**Catherine McAuley Catholic College, 507 Medowie Road, Medowie (SSD 8989)
Notice of Exhibition**

TAB A – Detailed comments on SSD 8989

Figure 16: Future Traffic and Transport. Reference Medowie Planning Strategy Dated 13 December 2016

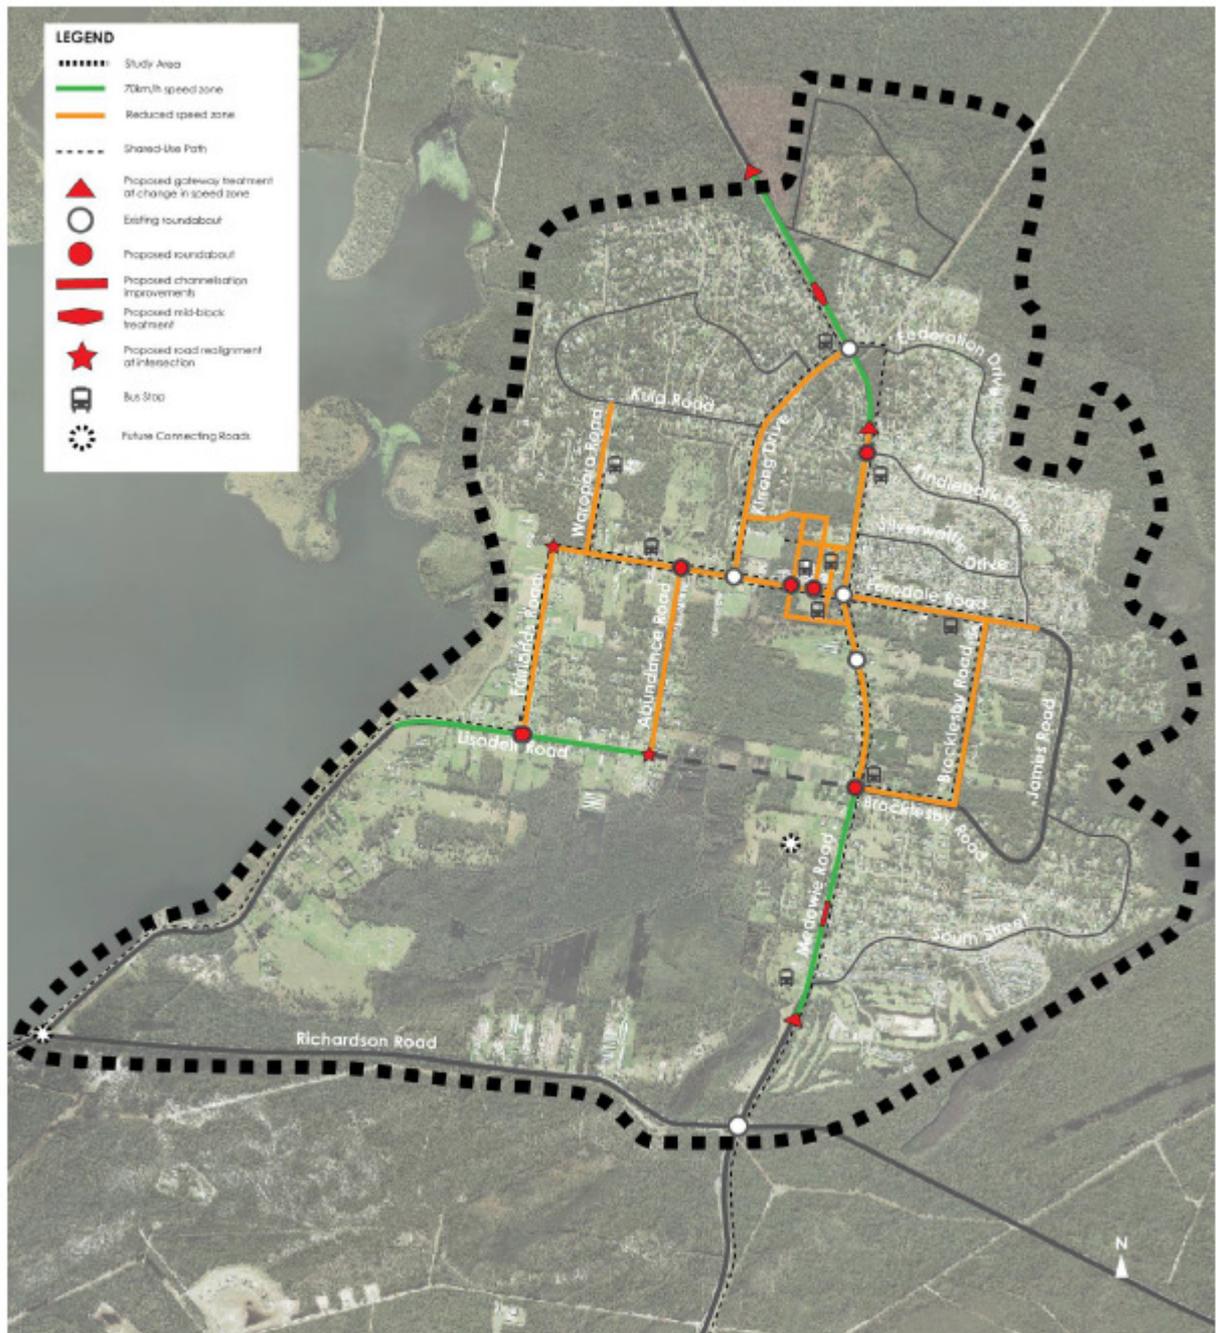
The Medowie Planning Strategy (Port Stephens Council, Dec 2016) includes a future shared-use path along the eastern side of Medowie Road; see Figure 9.

The footprint of the proposed intersection/widening at Medowie Road and South Street, as shown in the "Site Plan – Overall" drawings, appears to approach the property boundary of the dwelling/business on the corner of the intersection. It is unclear whether the remaining width between the road carriageway and road reserve boundary could accommodate any future shared-use path.

The proposed intersection works should be designed to make allowances for a shared-use path, along the eastern side of Medowie Road as indicated within the Medowie Planning Strategy, to be constructed within the existing road reserve.

Figure 21: Site Vehicular site access and parking arrangement

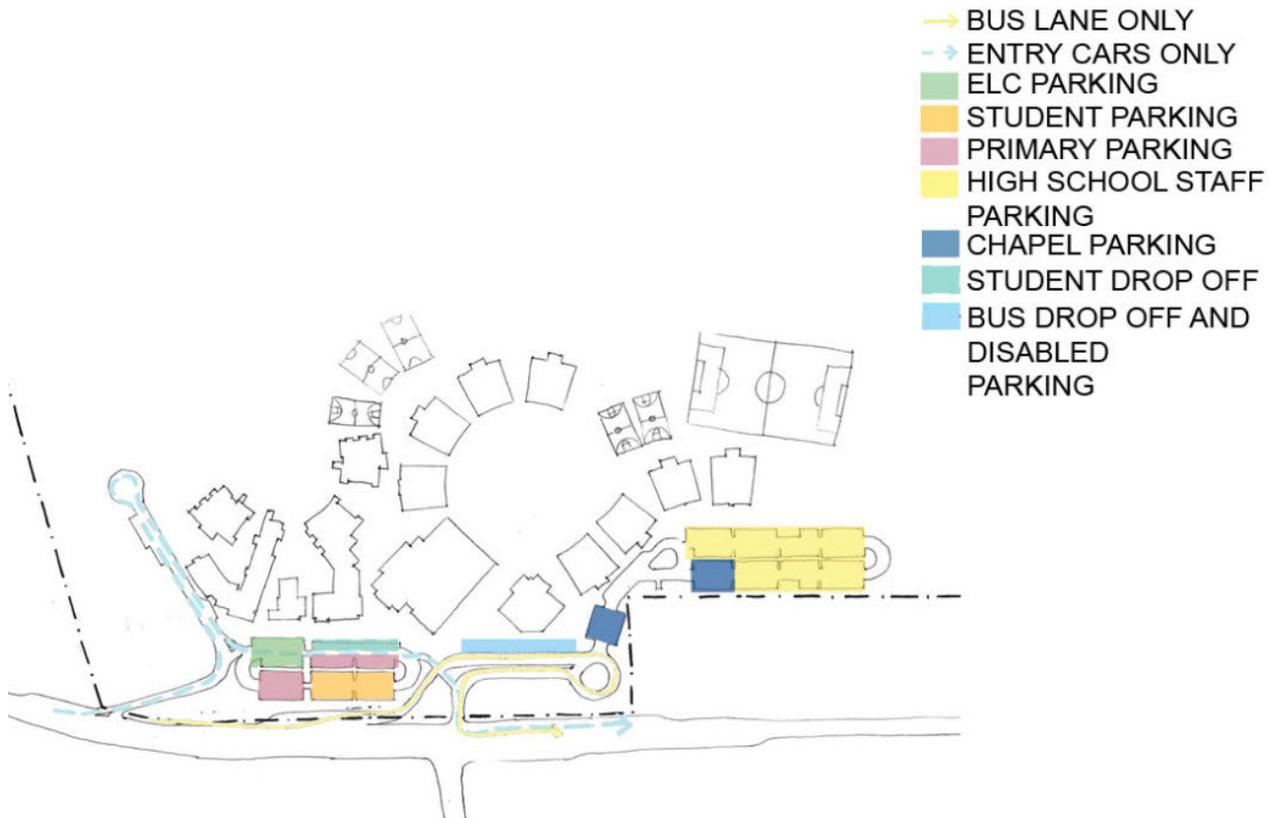
Insufficient information has been provided regarding the proposed intersection works. The current information provided has been limited to an architectural site plan, which does not detail key road features such as lane widths, accurate line markings, turning bay lengths, pedestrian crossings, signal locations or footpaths. As such, it is unclear as to whether the future intersection(s) could operate safely with the layout provided.

The "SITE PLAN CENTRAL" plan indicates that the bus pick-up/drop-off area is also intended to be used for Disability Parking. The proposed signage "No Parking 8:00am-9:30am; 2:30pm-4:00pm; Buses Permitted", is not in accordance with the RMS Technical Direction TDT 2013/07 Bus Layover. Furthermore, the use of the proposed signage would not effectively enforce the restriction of the bays for its intended use.

It is unclear from the road design plans whether buses heading south along Medowie Road would be able to utilise the bus entry access via a right-in movement.

The design of the internal road network should minimise vehicle conflicts on key circulation roads. There are currently two key conflict points, which could have an increased risk of vehicle collisions:

- The southern access, which is a two-lane entry and will be used by vehicles turning left-in and right-in from Medowie Road. The two-lane arrangement could potentially result in simultaneous left-in and right-in movements. The geometry of the internal road (resulting in approx. 150-160 degree turn) for right-in movements could result in drivers misjudging the turn resulting in conflict with oncoming vehicles (right/left crash – RUM code 23).

- The proposed circulation road from Car Park 1 to the intersection on Medowie Road crosses a bus circulation road leading to the bus drop-off point. It appears that "give-way" linemarking has been proposed to permit bus priority. However, given the proximity of the new signals and the relatively short queue lengths, there is the potential that drivers may disregard the priority controls or accept unsafe gaps in the case where the signal lanterns are green for outbound movements onto Medowie Road.

The Applicant should demonstrate that there is a principal acceptance from Council and Roads & Maritime Services for the proposed signalisation of Medowie / South Street and the proposed site access. At a minimum, the applicant would need to provide a concept plan to Council and Roads & Maritime Services satisfaction of the proposed intersection works (prepared by a suitably qualified traffic engineer).

It is recommended that the Applicant revises the proposed parking arrangements within the bus

pick-up/drop off zone with the objective to separate general traffic movements from bus loading areas.

The bus pick-up/drop-off zone needs to be, at minimum, signposted as a timed Bus Zone.

The Applicant should confirm whether buses heading south along Medowie Road would be able to utilise the bus entry access via a right-in movement.

The Applicant should revise the internal road network with the aim to minimise vehicle conflicts on key circulation roads.

An option that could be investigated would be to initially physically separate (median separation) the entry lanes at the southern access and reduce the turning angle (closer to 90 degree turn) to

reduce the chance of driver understeer.

Furthermore, the Applicant should consider removing the option to cross the bus entry circulation road and pursuing alternative vehicle circulation routes to eliminate the potential for cross traffic collisions (RUM code 10).

Finally, all key circulation movements should be supported with swept path analysis/modelling.
